Our Ref: 1259004000

20 November 2012

RE: RPA NORTHWEST PRECINCT REDEVELOPMENT – RESPONSE TO TRAFFIC MATTERS

GTA Consultants has reviewed the traffic, on-site parking and loading matters as they relate to the Royal Prince Alfred Hospital (RPAH) Northwest Precinct Redevelopment and in particular comments by the Department of Infrastructure and Planning (DoPI), the City of Sydney (CoS) and Transport for NSW (TfNSW) in each respective letter of response to the project application (MP 10_0166) dated August 2012.

DEPARTMENT OF PLANNING SUBMISSION
LOWER GROUND LEVEL PLAN

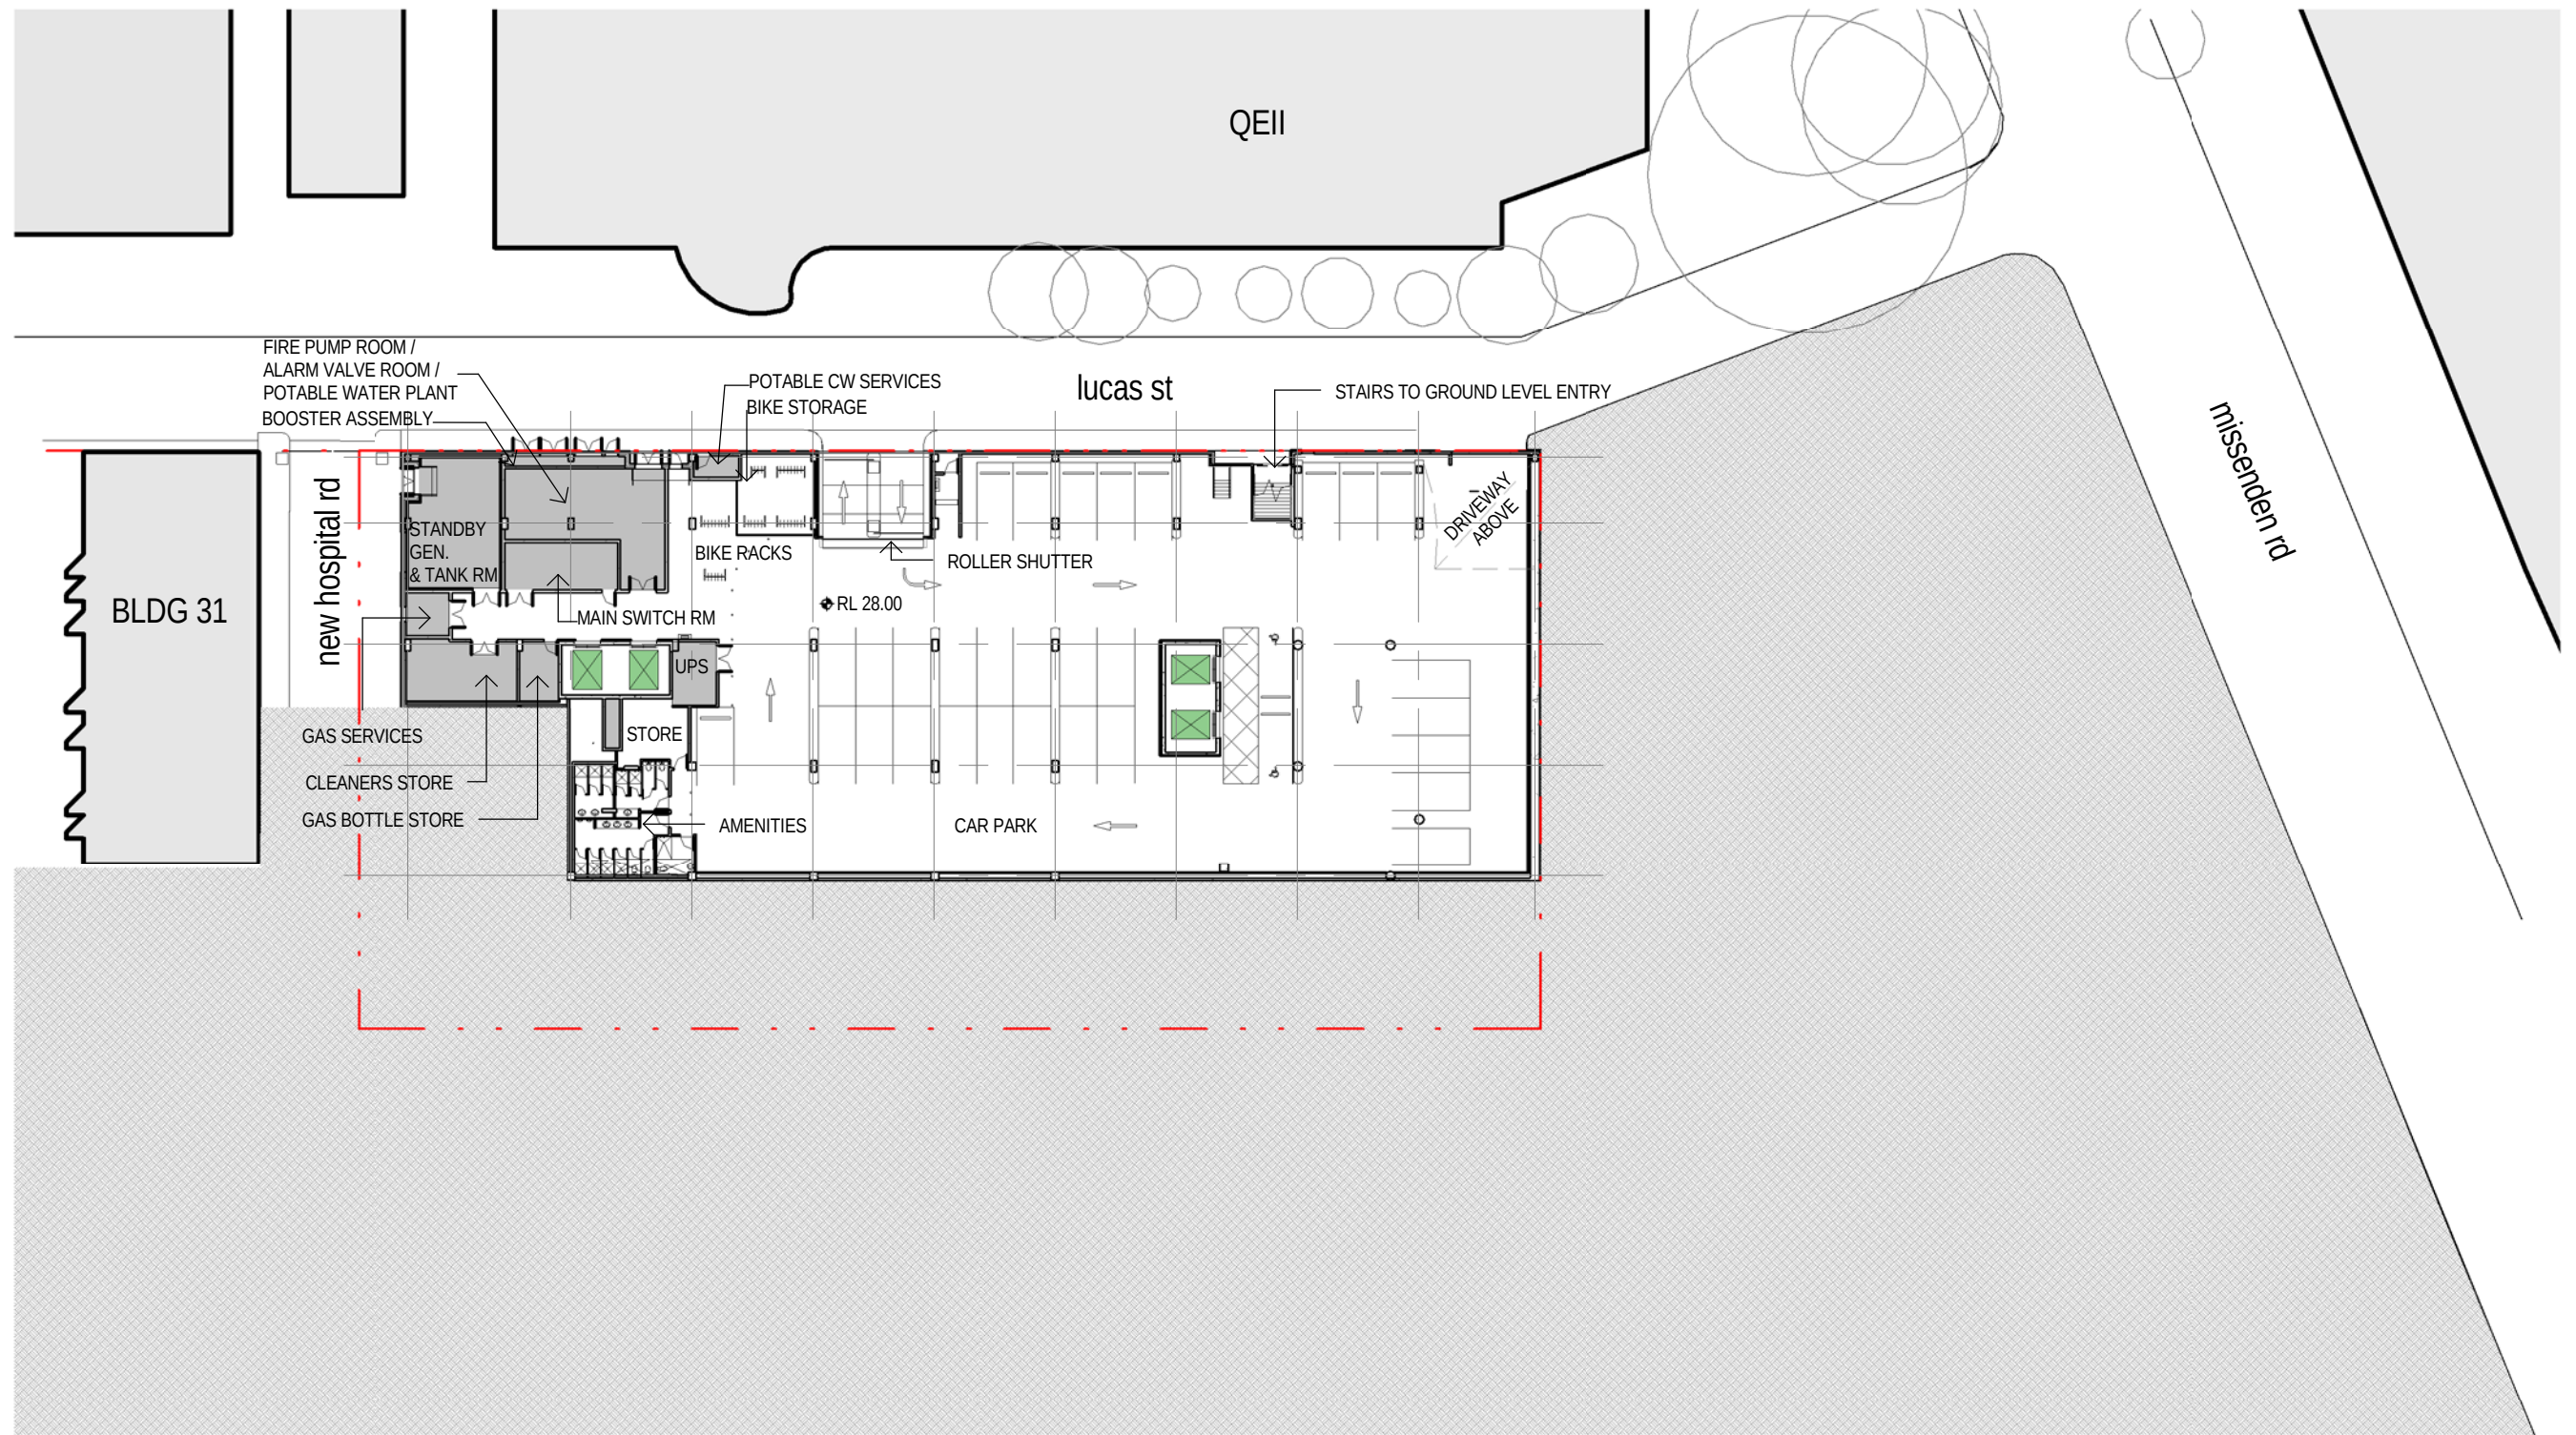
A maximum of 38 off-street car parking spaces must be provided. The design, layout, signage, line marking, lighting and physical controls of all off-street parking facilities must comply with the minimum requirements of Australian Standard AS/NZS 2890.1 - 2004 Parking facilities Part 1: Off-street car parking and Council's Development Control Plan. The details must be submitted to and approved by the Principal Certifying Authority prior to a Construction Certificate being issued.

Noted. The basement level car park provides undercover parking for 32 vehicles and complies with the requirements of AS2890.1:2004. A compliance review and swept paths are included in this response as Attachment B.

GROUND LEVEL PLAN

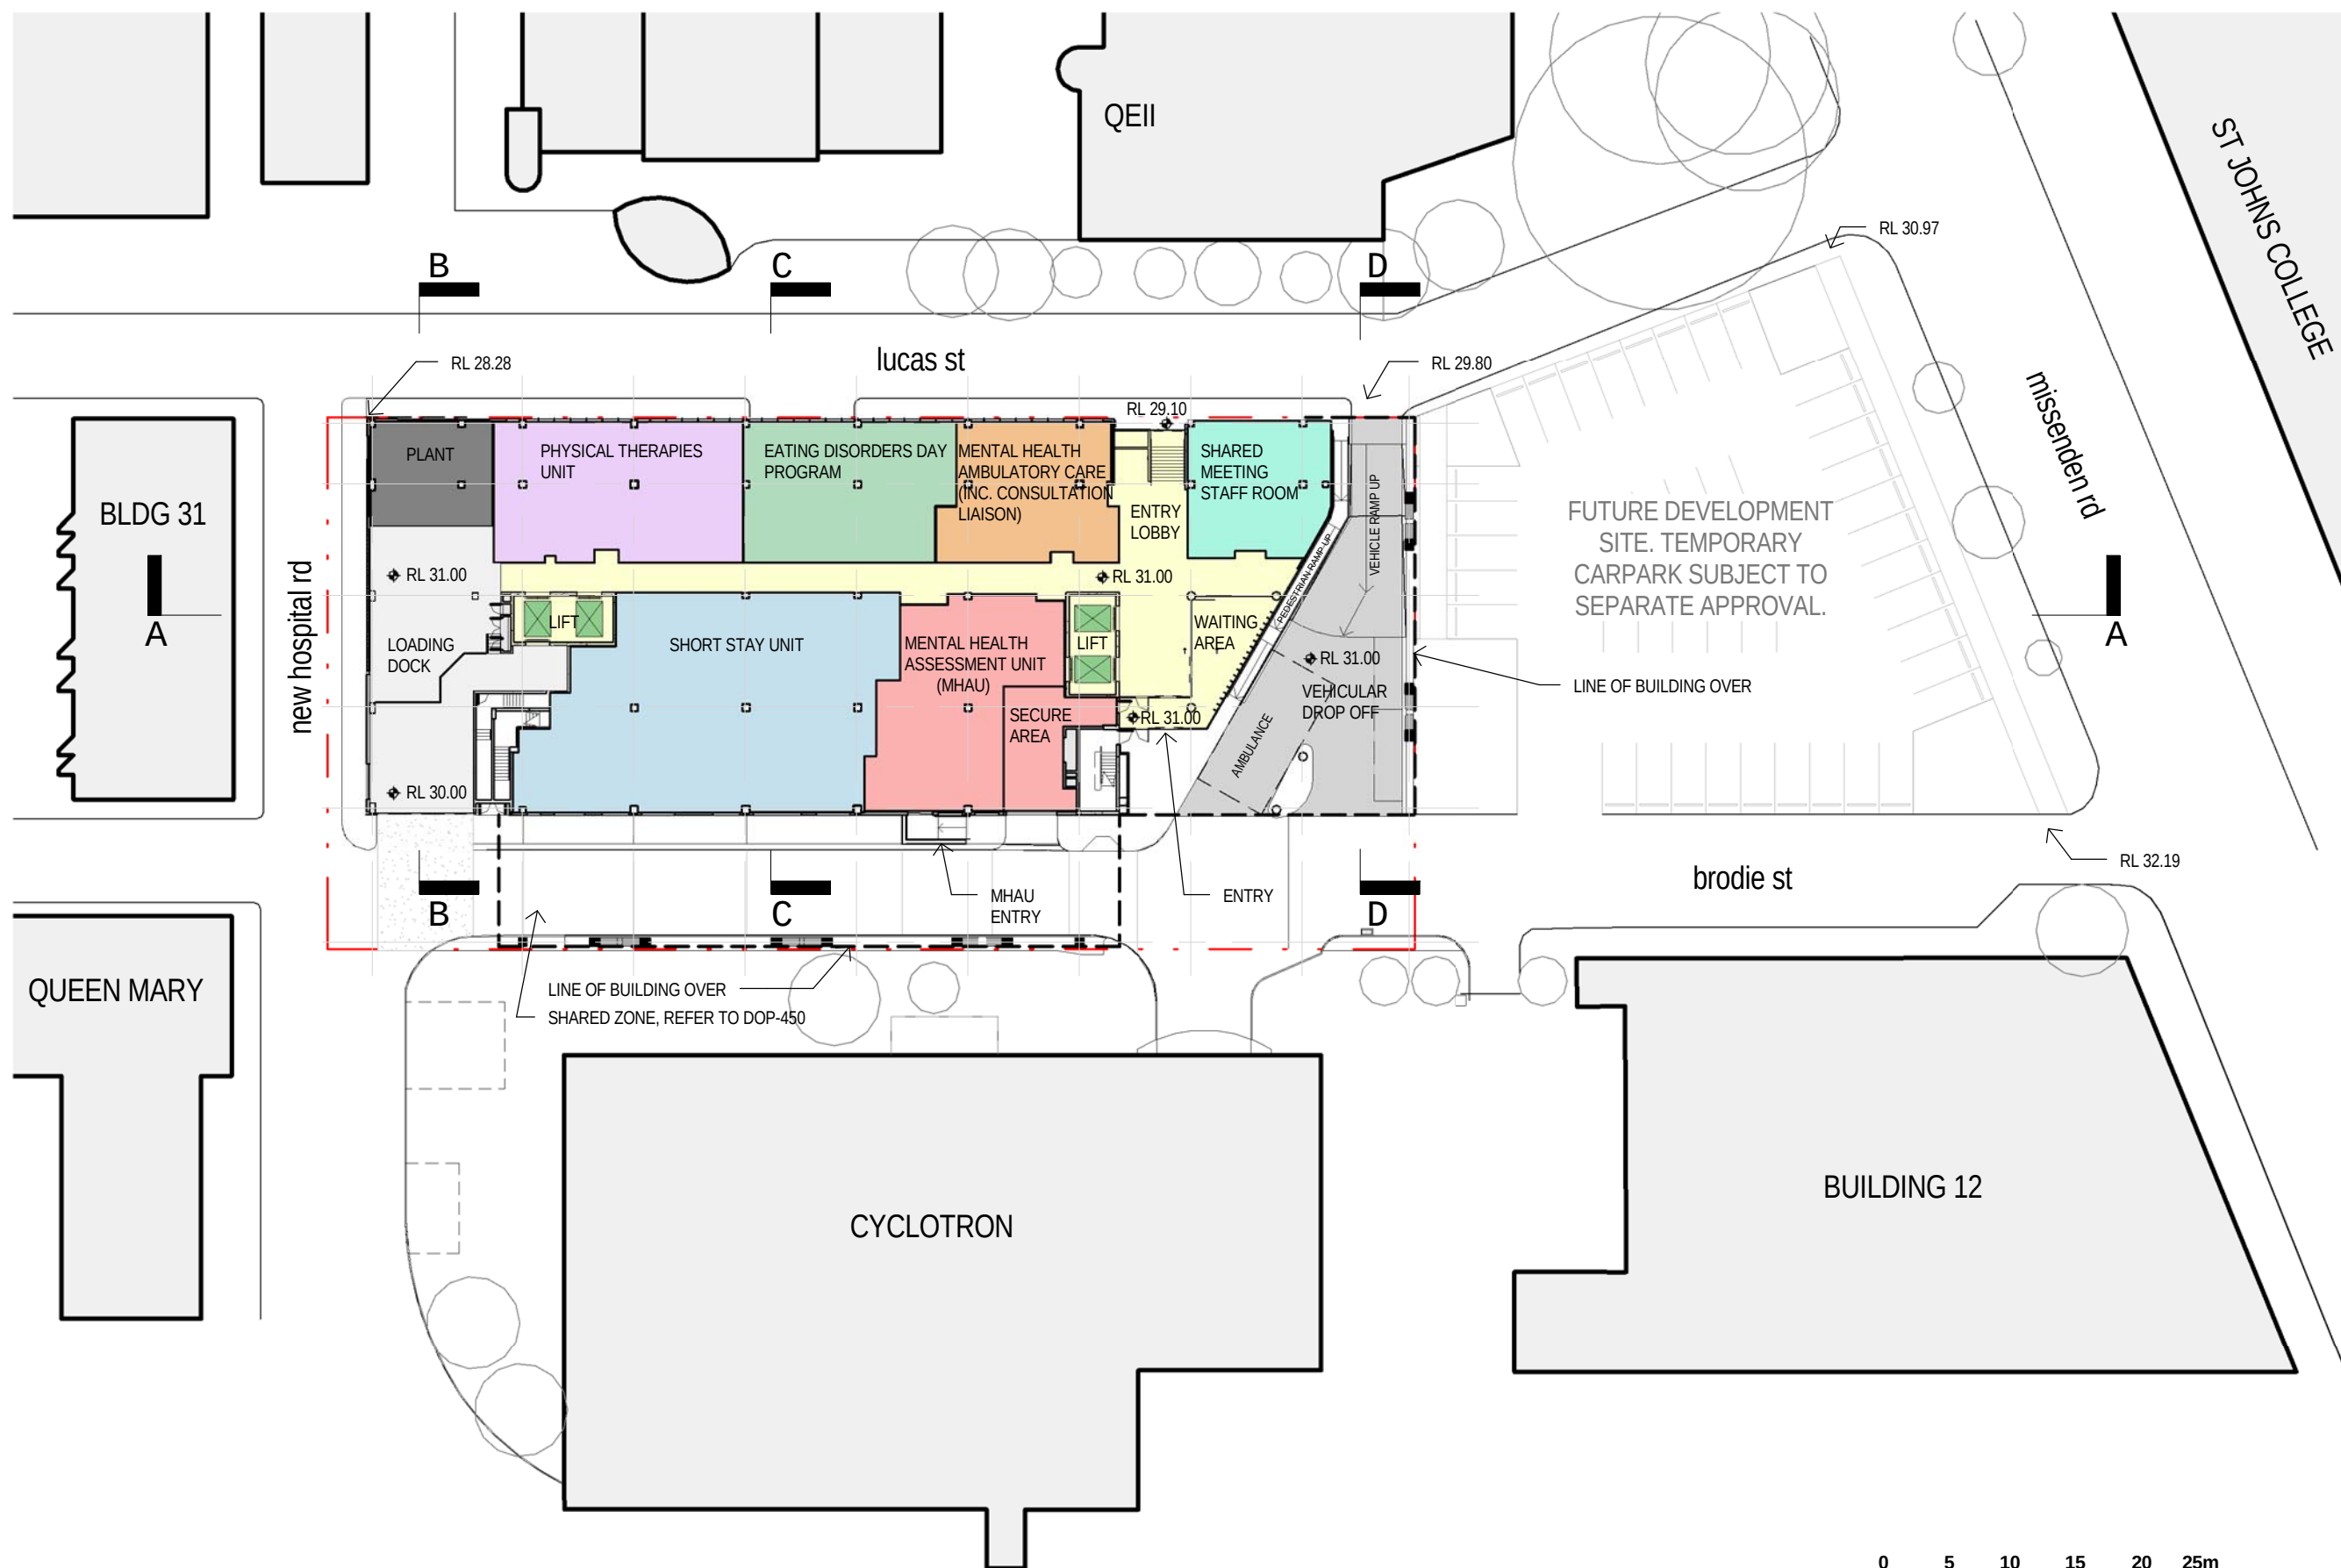
The proposed loading arrangements require manoeuvres that are considered to be unsafe. Specifically, the swept paths show that:

- i. vehicles entering and exiting the loading area will be required to perform u-turns and reverse through the intersection of Brodie and Hospital Road; and*
- ii. vehicles entering the loading area will also need to reverse through the proposed shared zone on Brodie Street.*

Both movements requiring manoeuvring and reversing through an intersection zone and vehicles entering the loading area also need to reverse in to a shared pedestrian zone. Both movements are considered unsuitable for a new development and it is recommended that the loading arrangements be reviewed and redesigned.

A shared zone is proposed for the private road, Brodie Street. Loading, including garbage, patient drop off and ambulance vehicles will use this shared zone to access the site, and as discussed above, accessing the loading area will require reversing through the shared zone. Brodie Street is identified as an important pedestrian connection through the site. Concern is raised that the design will create conflict between vehicles and pedestrians resulting in safety issues and it is recommended that the area be redesigned (possibly with a separated footway of sufficient width be provided).

Swept paths show Service vehicles will exit the loading area via New Hospital Road (south) and then Grose Street to access Church Street west of the site. As such, no reversing or u-turns will be required on exit.

The shared zone has been amended to begin/ end adjacent to the eastern alignment of the loading dock resulting in service vehicles manoeuvring mostly within Brodie Street, west of the shared zone and adjacent to New Hospital Road. Swept paths are included in this response as Attachment B.

This is addressed in response 1 to the Department of Planning and Infrastructure as detailed above. The design of the Brodie Street shared zone, together with the anticipated low traffic volumes, appropriate speed control signage and pedestrian activity ensures that the design is appropriate and in accordance with the requirements for a shared zone to ensure the safety of all users. No service vehicles will be required to reverse through the shared zone.
